10 July 2012

Your Ref :
Our Ref : R/134/12/NMA

Application for a non-material amendment following a grant of planning permission R/115/07/ to extend garage & minor amendment to south elevation fenestration
2 Cross Road, Rustington, ,

Drawing: Scale: 1: 100 Drawing No.: 06/3222/1
Date: APRIL 2007
Drawn: tu. Revisions: A B
Copyright: [Signature]

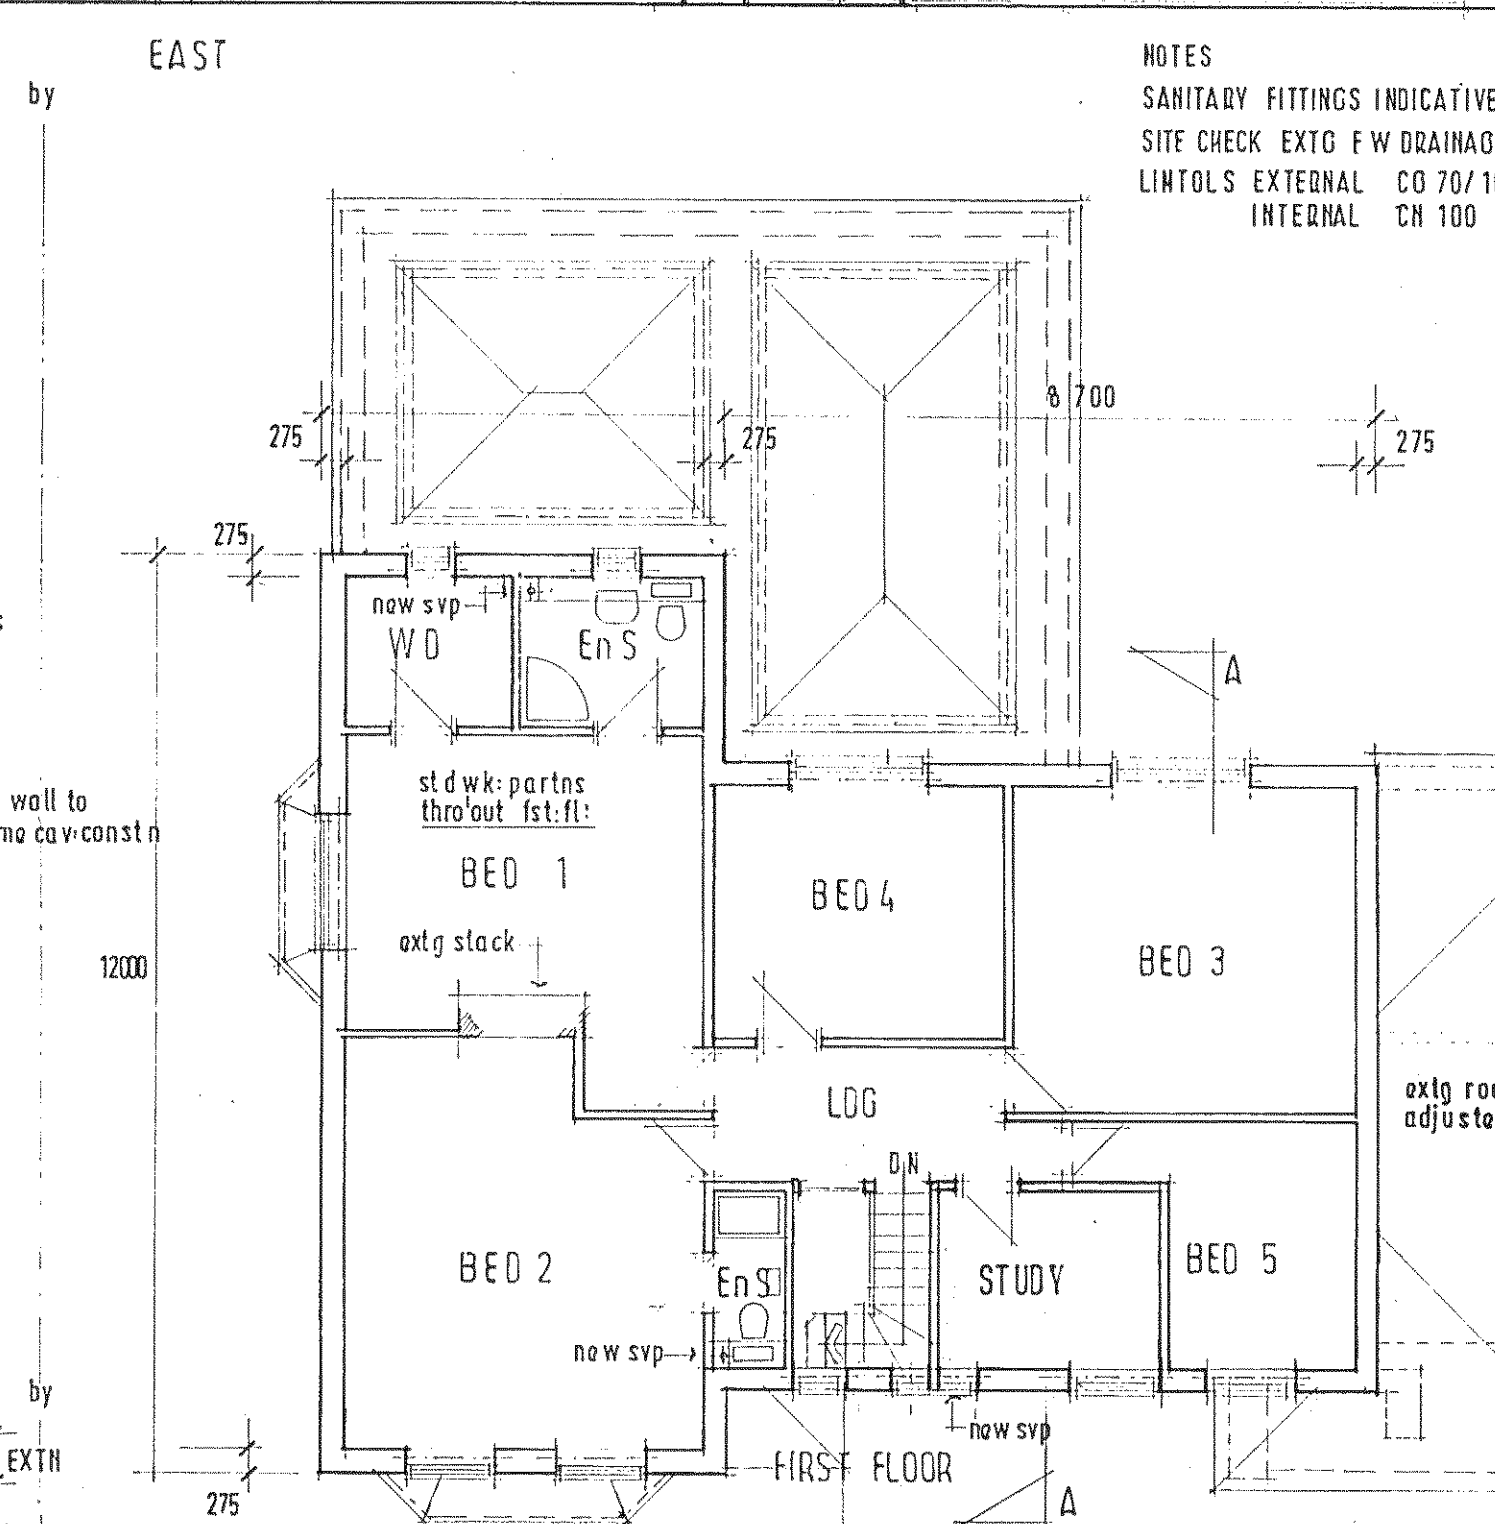
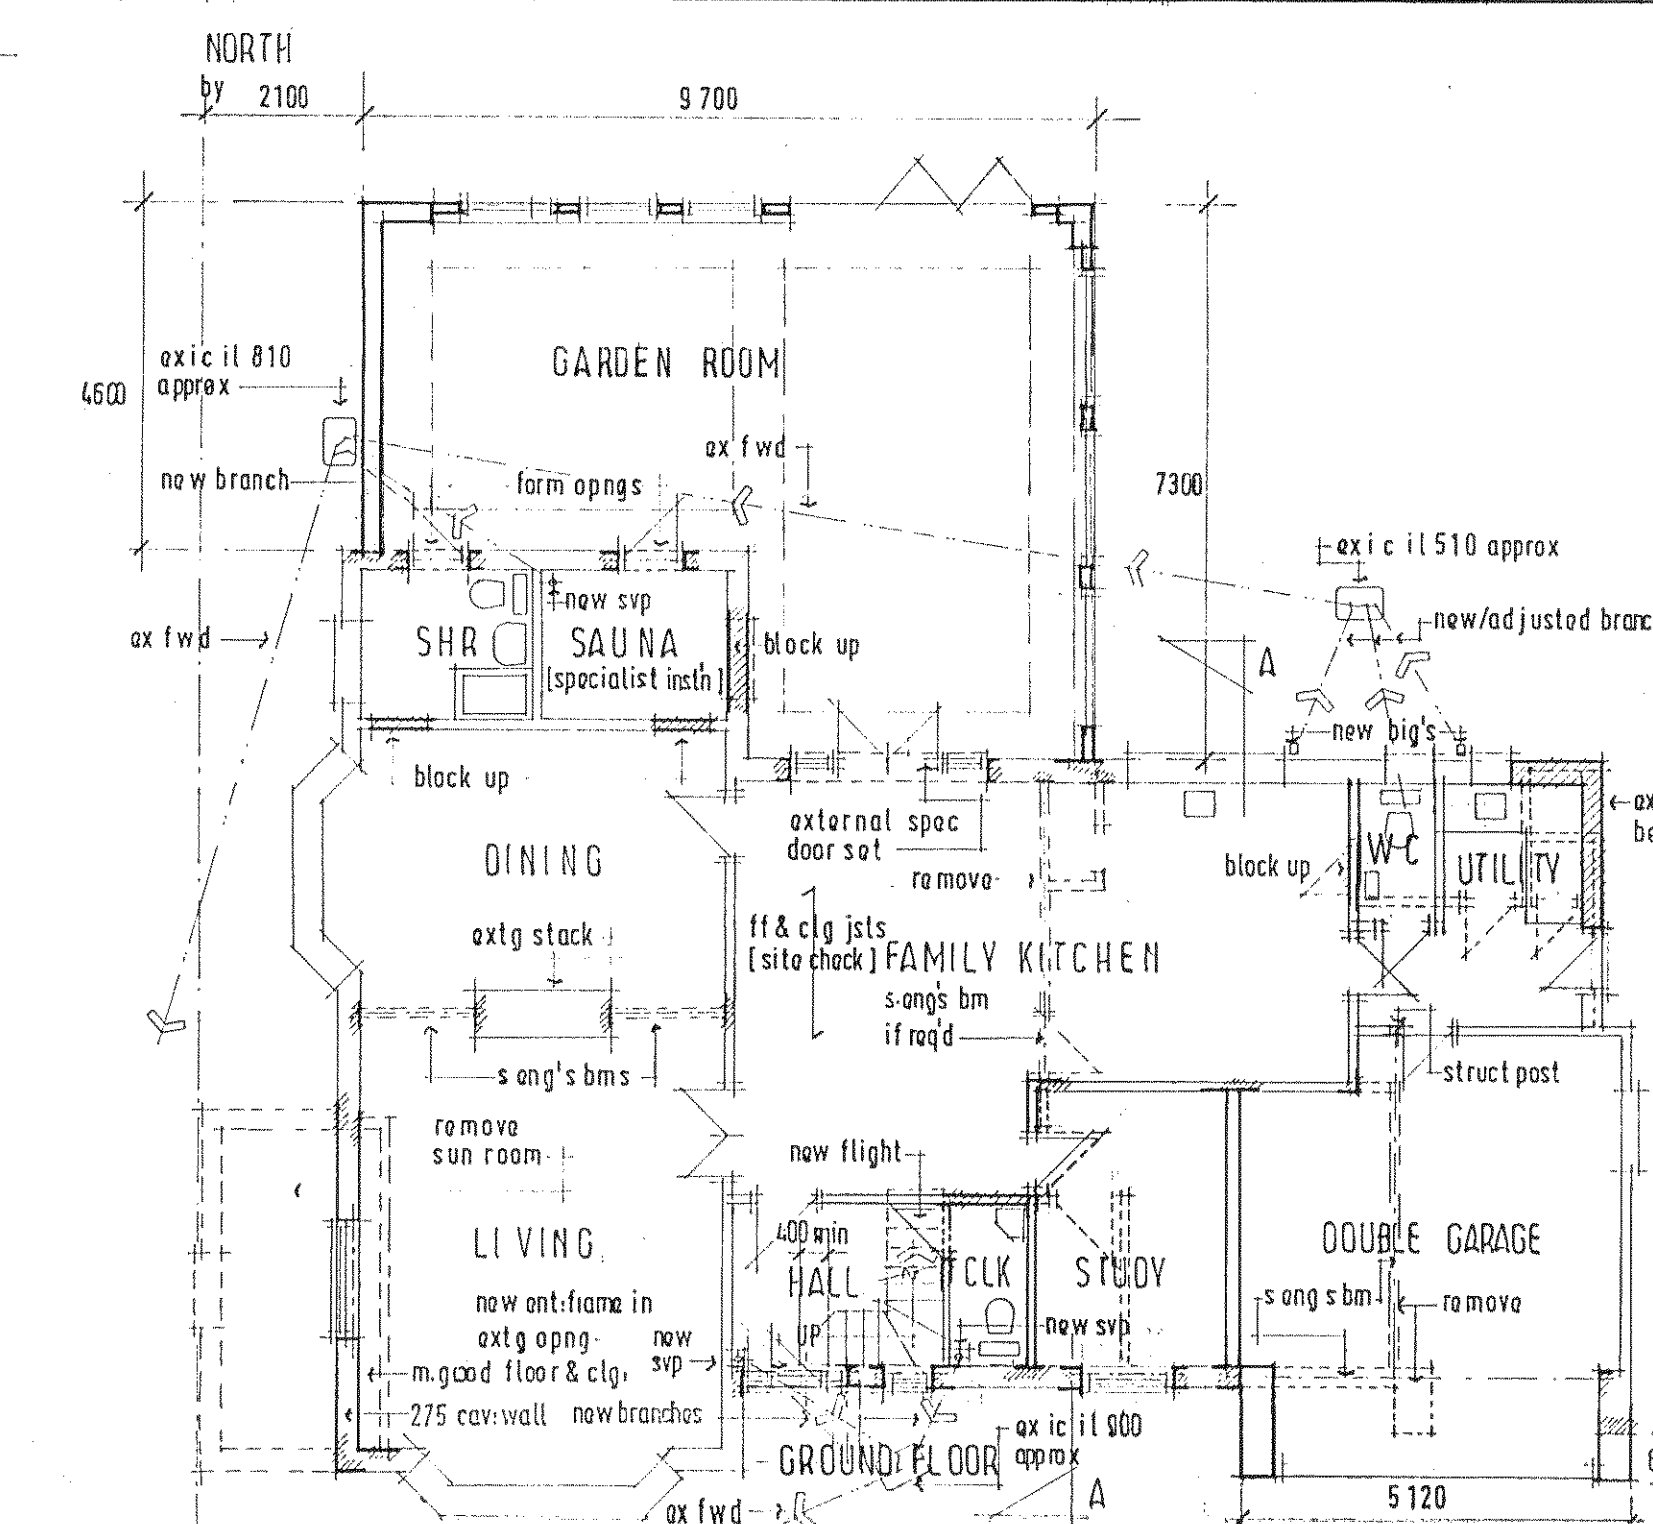
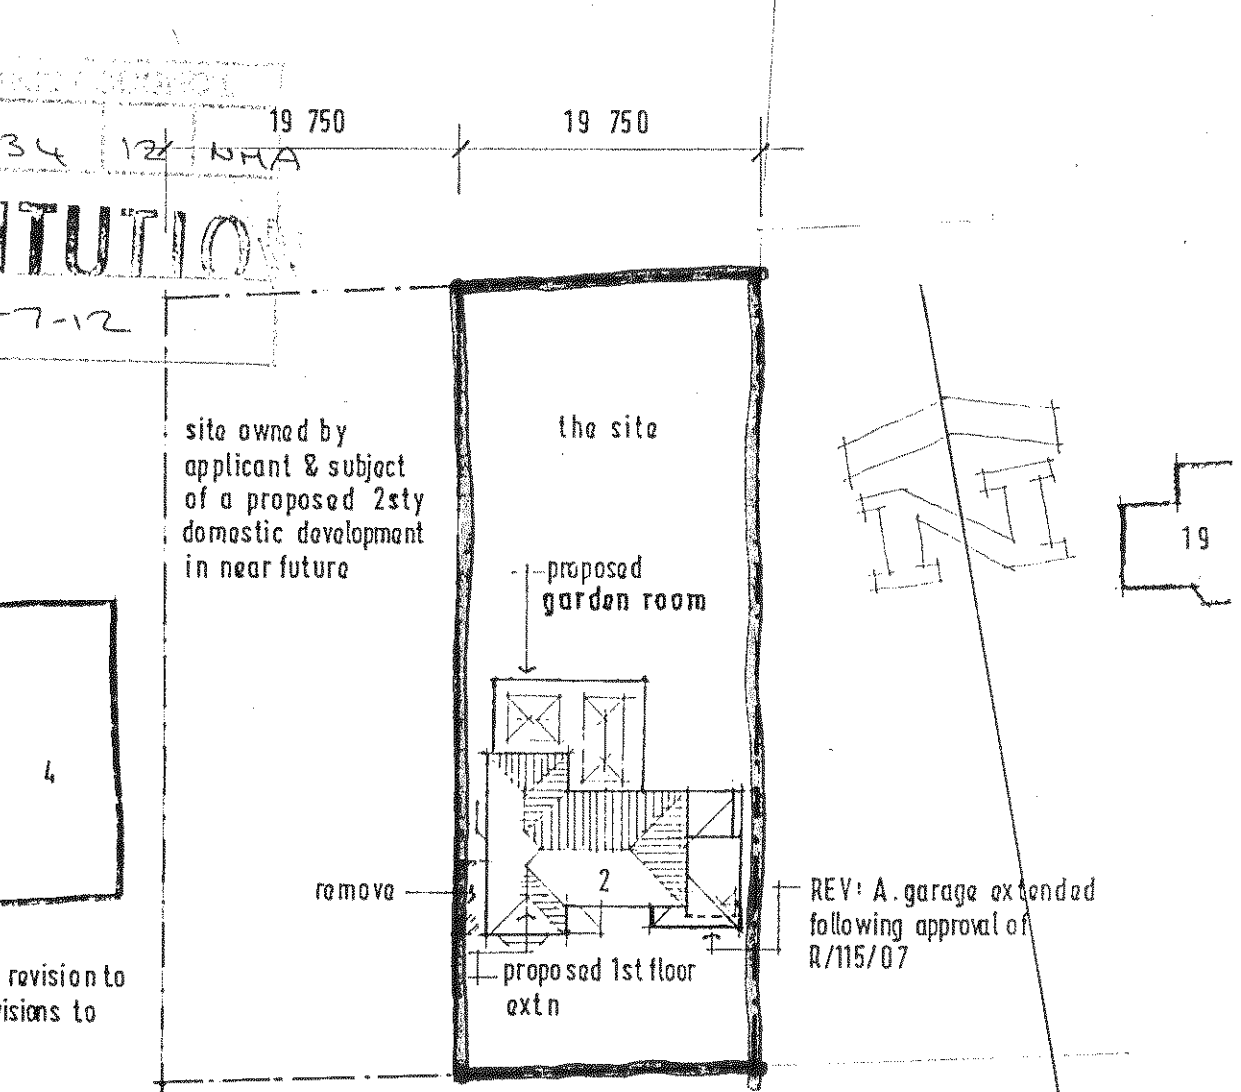
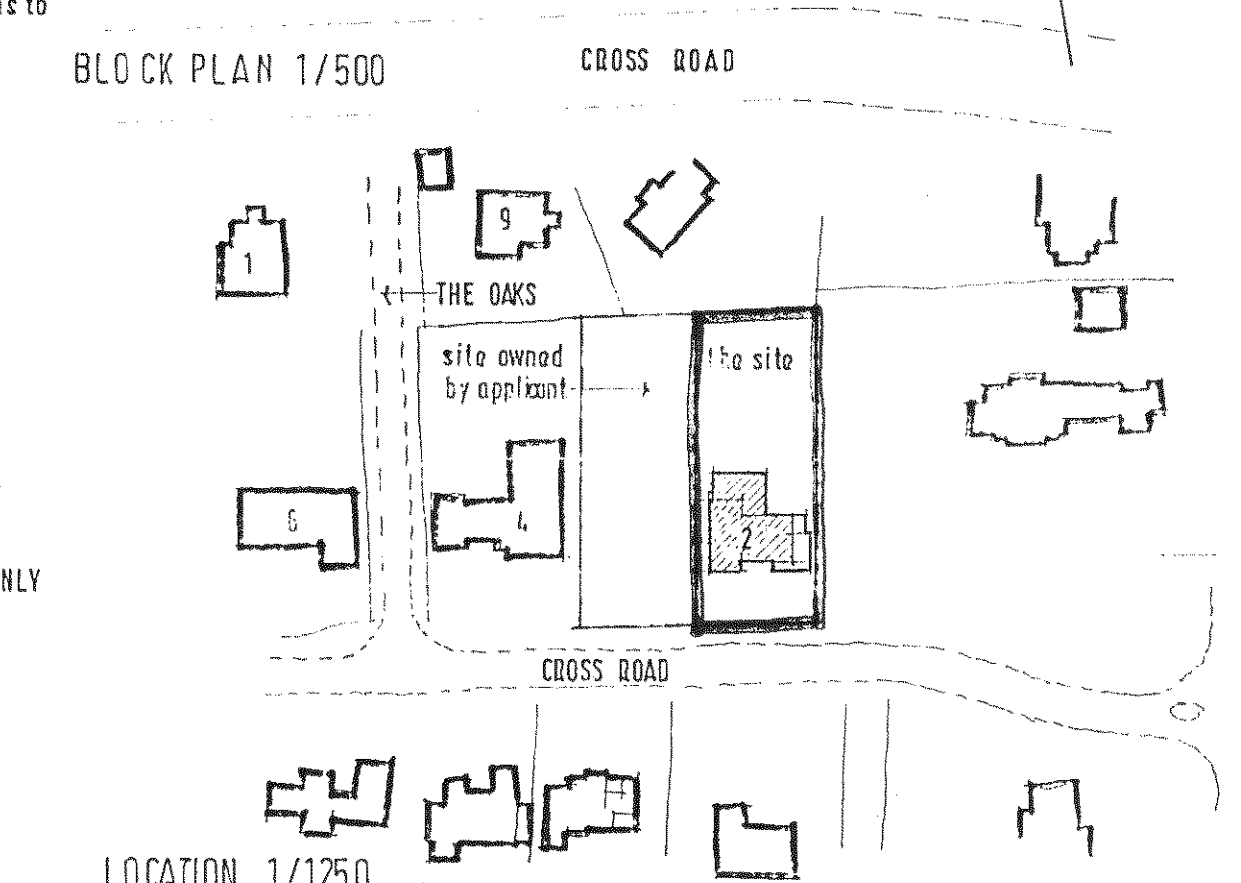
I refer to your recent application for a Non-Material Minor Amendment which I received on 20-06-2012. From the information submitted I am able to take the alterations set out below as a Non-Material Minor Amendment to R/115/07, namely:
Changes to profile of garage roof;
Changes to south elevation fenestration including porch over front door and window changes;
Changes from conservatory elevations to create garden room on same footprint;
Changes to north elevation including provision of roof lights;
Additional ground floor window on east elevation:
Additional ground floor window on west elevation and change to bay window;
Please note that drawing no.06/3222/1 revB has therefore become the approved plan for planning application R/115/07.
